16 PUBLIC SUBMISSIONS

Re Fullerton Cove Sand Extraction Project MP07-0145

FULLERTON COVE SAND EXTRACTION PROJECT MP07 - 0145

Figure 2.1 - Staging Plan

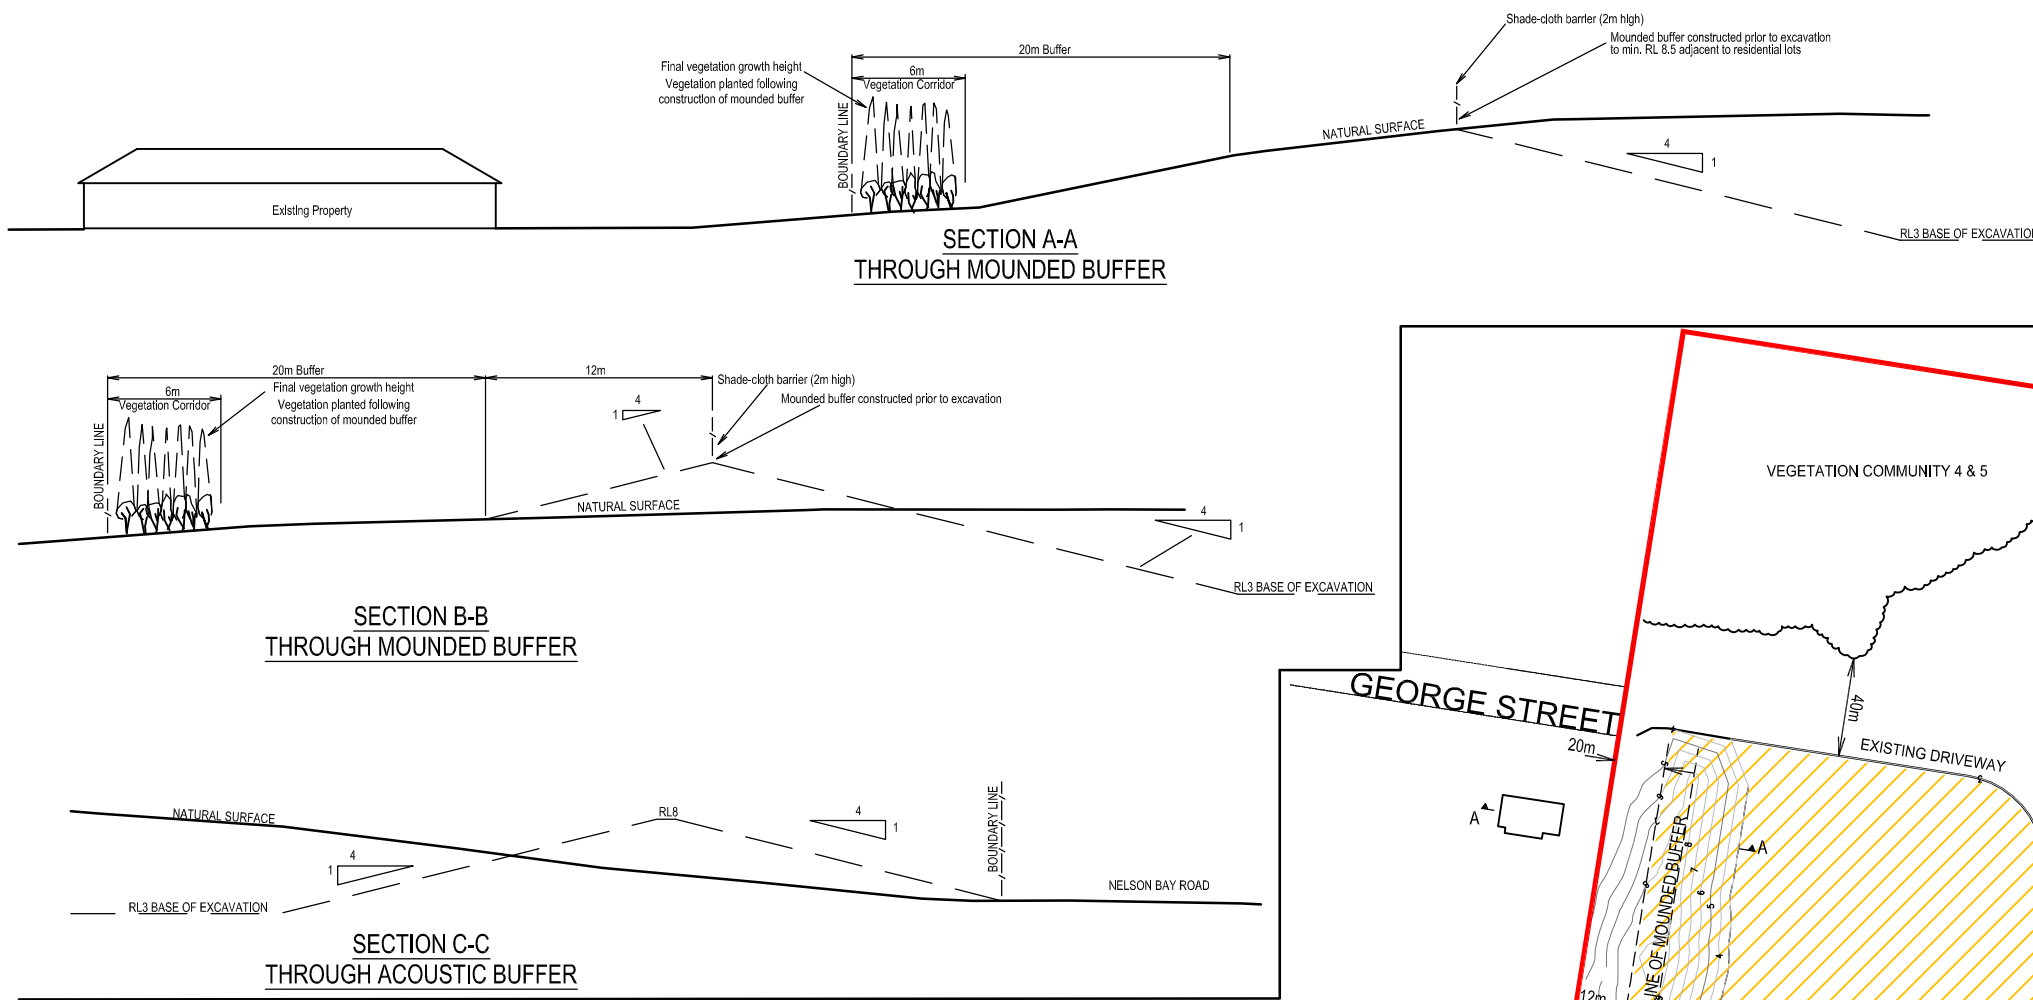
Furthermore, figures 2.1 and 2.4 of the EA indicate that the land adjoining our property will batter down, resulting in our property overlooking the development site. It should be noted that figure 2.1 *Previously Mined Area, Existing Landform and Proposed Extraction* area shows only the finished contours of the site, and does not indicate the extent of extraction and re-contouring that will occur along our property boundary. Please see Attachment A showing the existing and proposed levels in relation to our property and residence.

- **Protection of existing mature trees on boundary-** There are many mature trees located within one metre of the eastern and southern boundaries of our property adjoining the proposed sand extraction areas (see photo attached). The EA has failed to address potential impacts on these trees, specifically potential root damage and tree stability in relation to re-contouring and earthworks proposed along the site boundaries as shown on Figures 2.1 and 2.4 of the EA.
